PLANNING CONSULTATION RESPONSE

Application No	2026/0246
Proposal	Conversion of existing roofspace to create 3x residential flats, with associated external alterations including installation of rooflights.
Address	Family Shopper, West Street, Hoyland, Barnsley, S74 9DU
Date of Consultation Reply	13/08/2026
Consultee	Pollution Control

TYPICAL SECTION @ 1:20

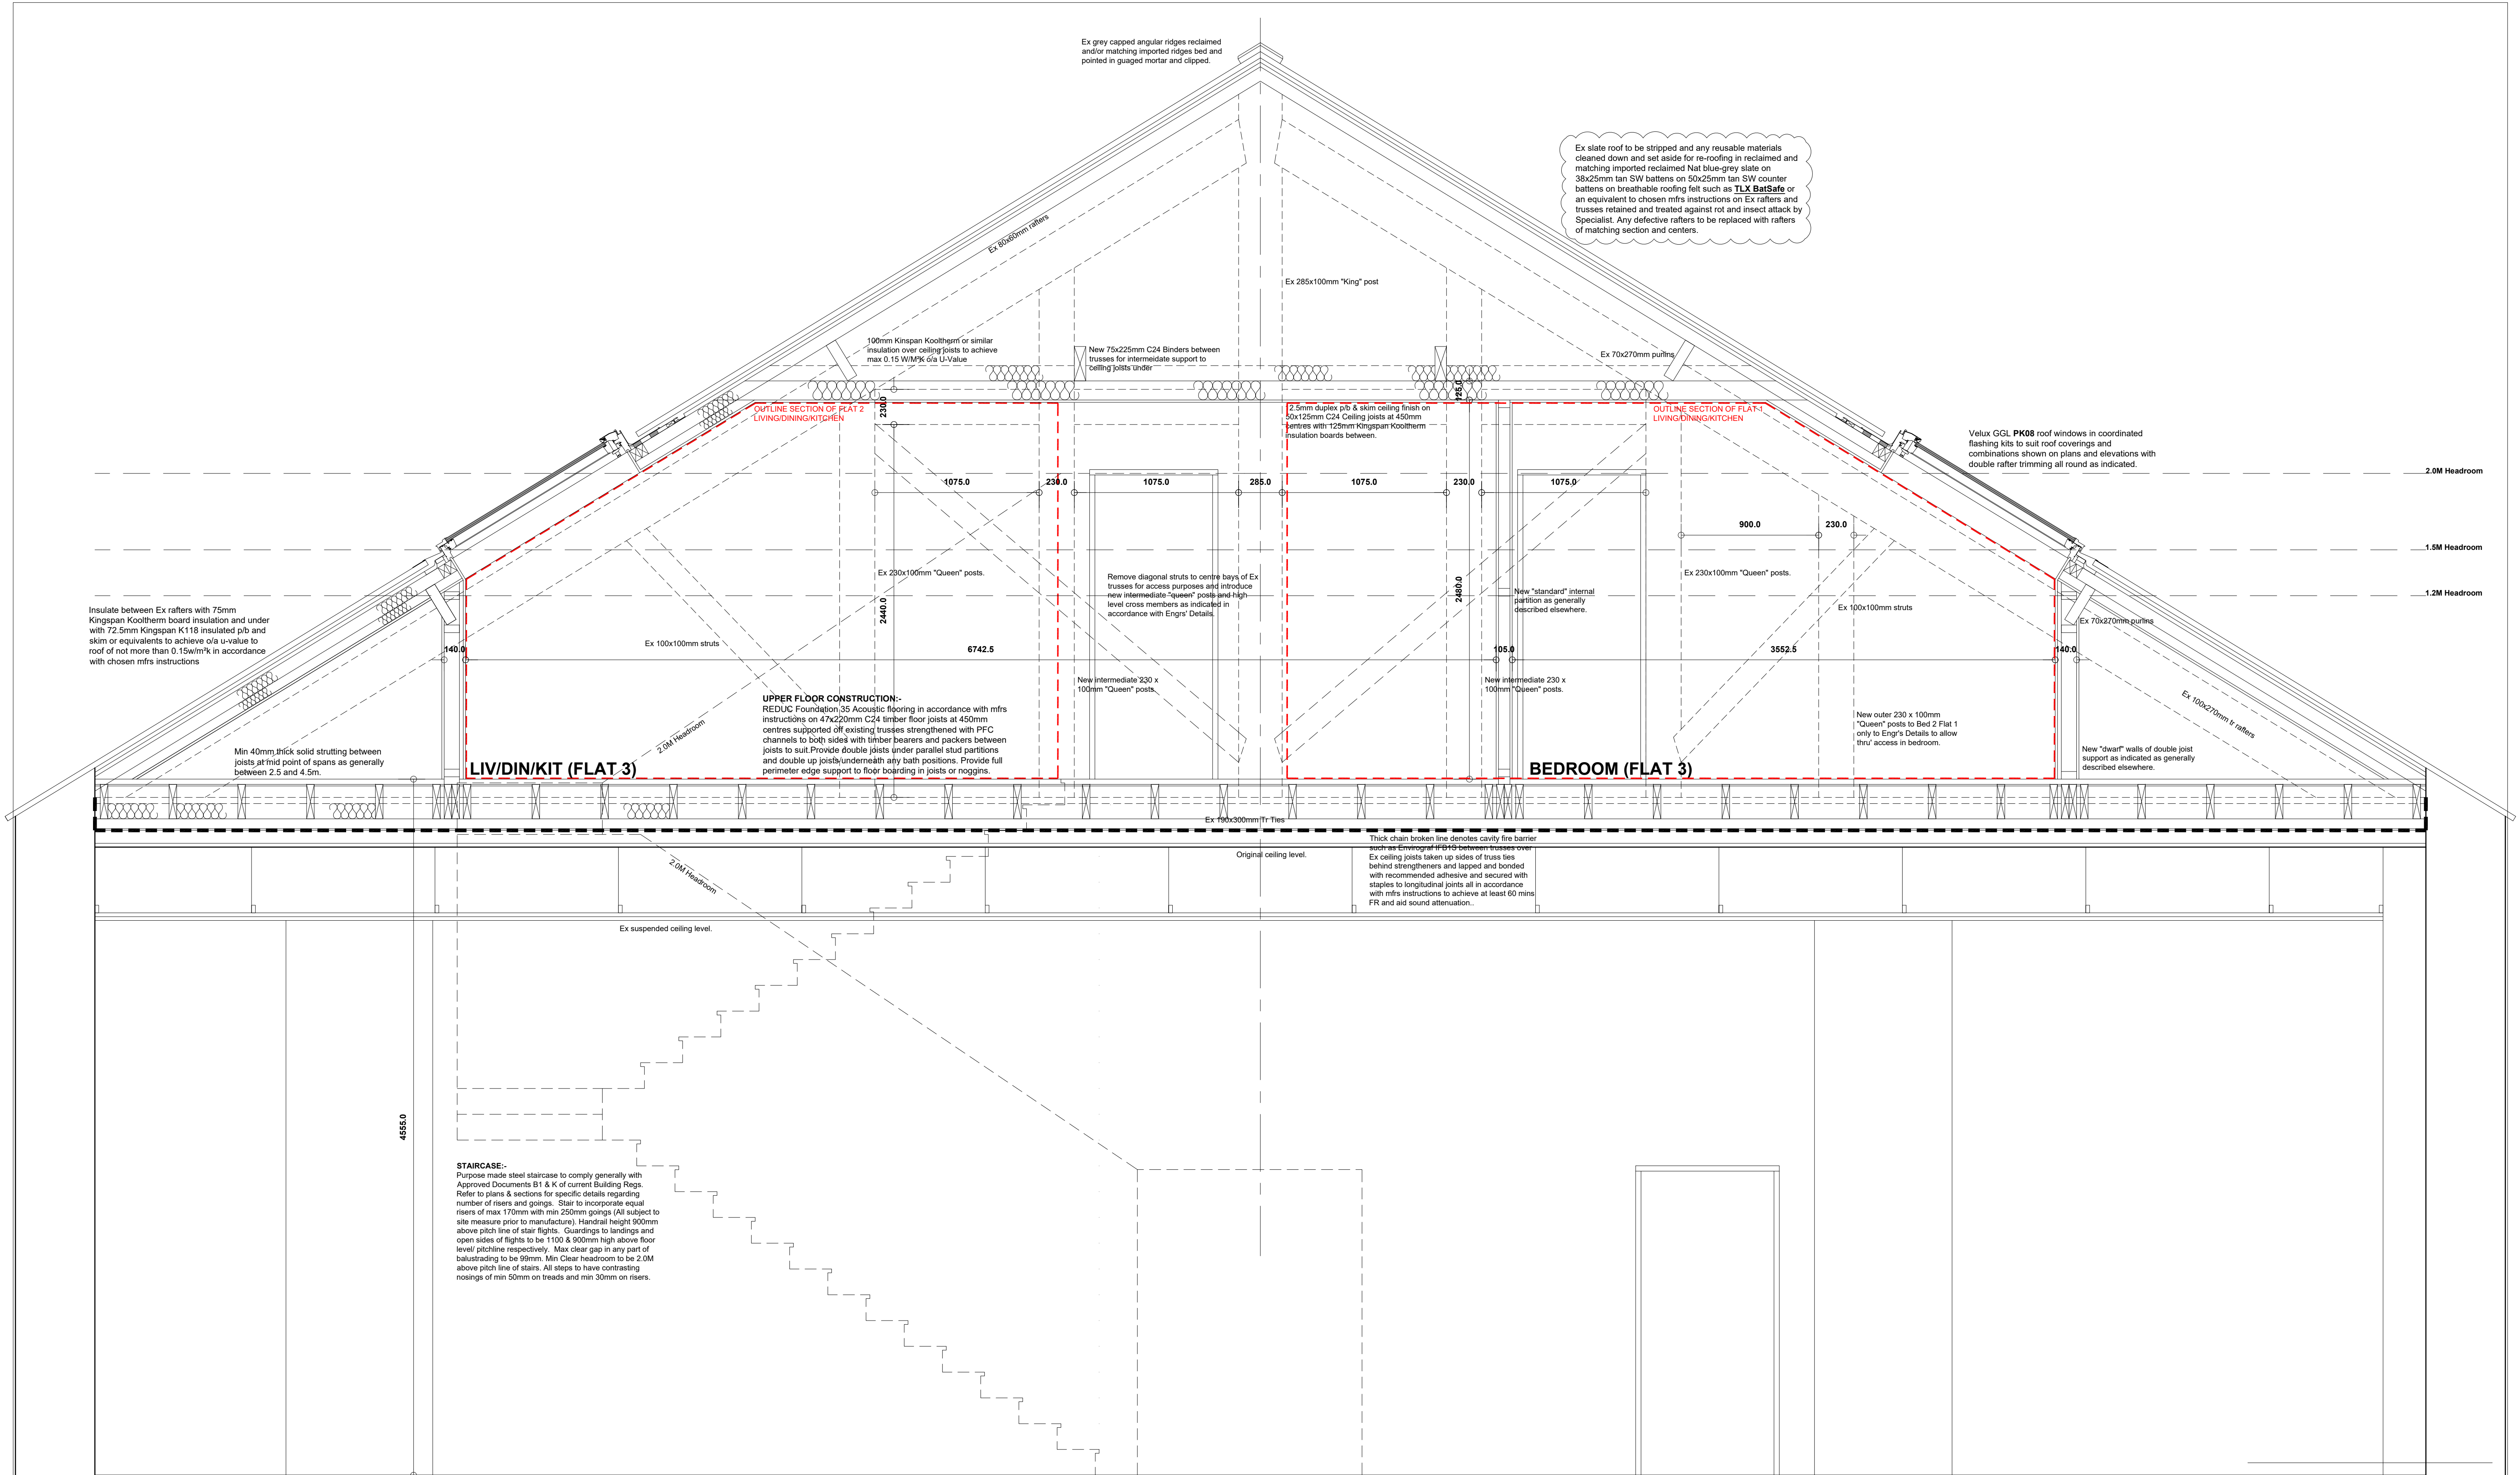
The proposed development is located above a dance studio and gymnasium, both of which are likely to be sources of noise which could transfer to the proposed accommodation if adequate acoustic insulation between the floors is not provided. There does not appear to be any detail of this provided in the application. Sound insulation testing is required with appropriate mitigation identified in order to ensure sound transference is minimised between floors 1 and 2.
